Planning Application No: 3/2024/0358

Proposal: Proposed two-storey and single storey extension to rear and single-storey porch to front. Two new first floor windows in side gable elevation.

Location: 34 Jeffrey Avenue Longridge PR3 3TH

The submitted documents and plans have been reviewed and the following comments are made.

Proposed Site Plan 1:200

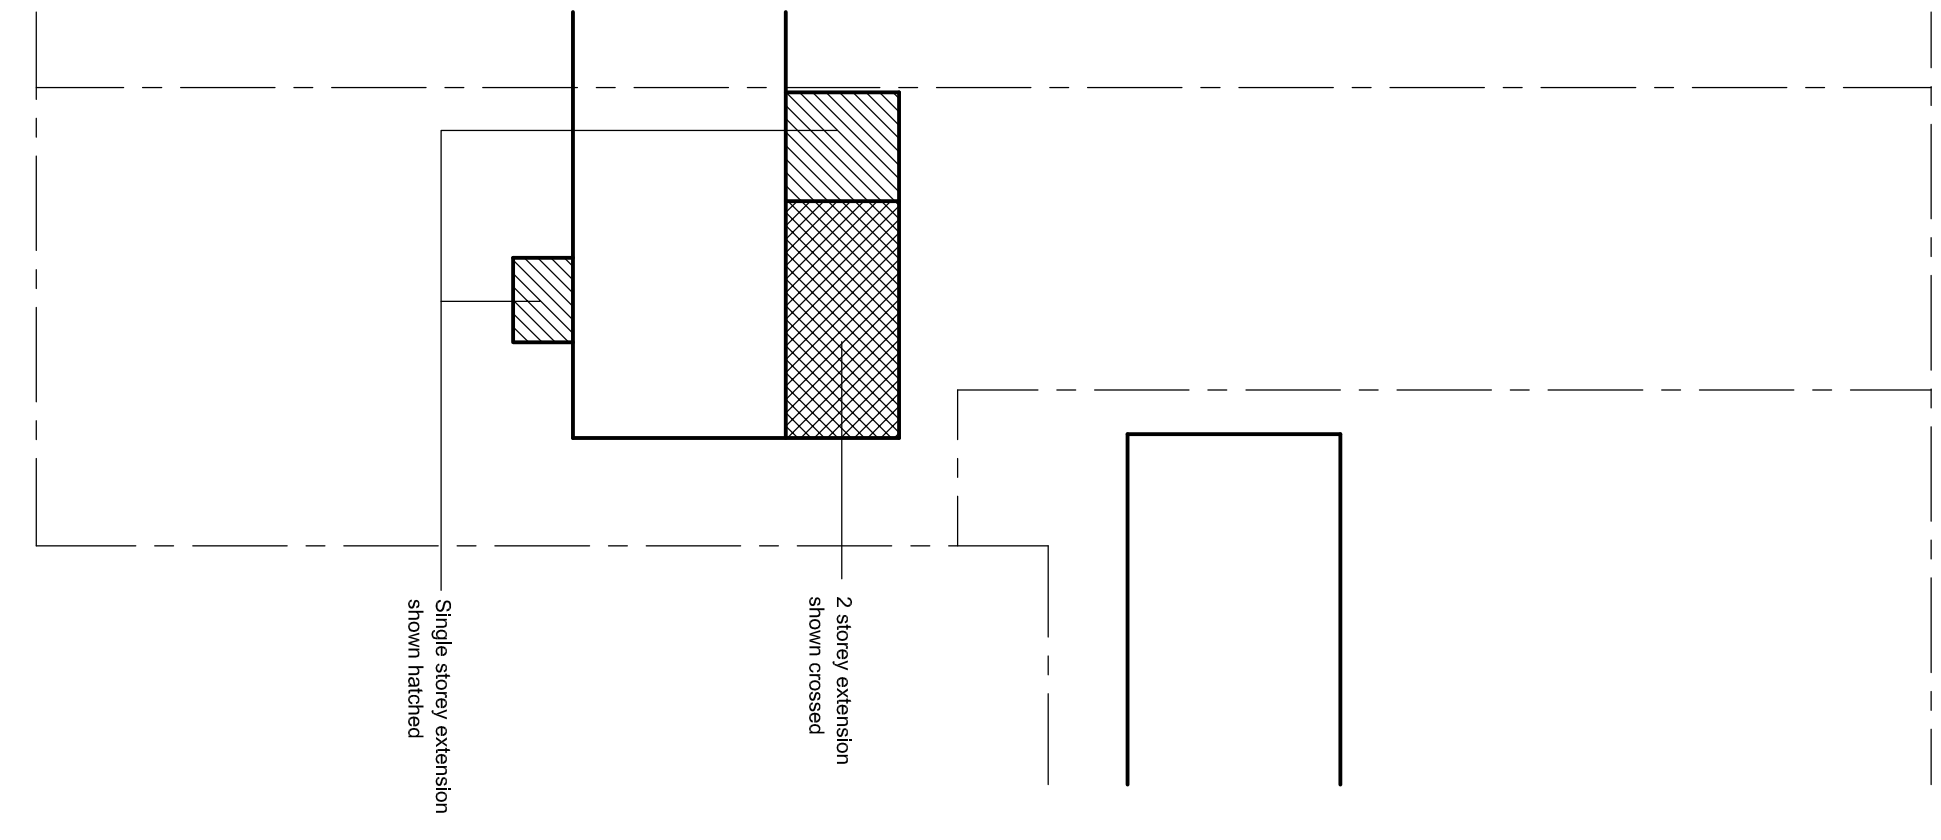
The proposal creates a loss of a shed and a proposed increase in number of bedrooms from 3 to 4. Parking standards require 3 parking spaces for this size of proposal to be provided on the drive. No parking plan has been submitted; however it is noted there is no change to the existing parking arrangements.

Cycle parking must be provided for 4 cycles for the promotion of sustainable forms of transport and aid social inclusion.

1. Prior to first use of the premises hereby approved a secure covered cycle store shall be provided and maintained thereafter for as long as the premises are in use.
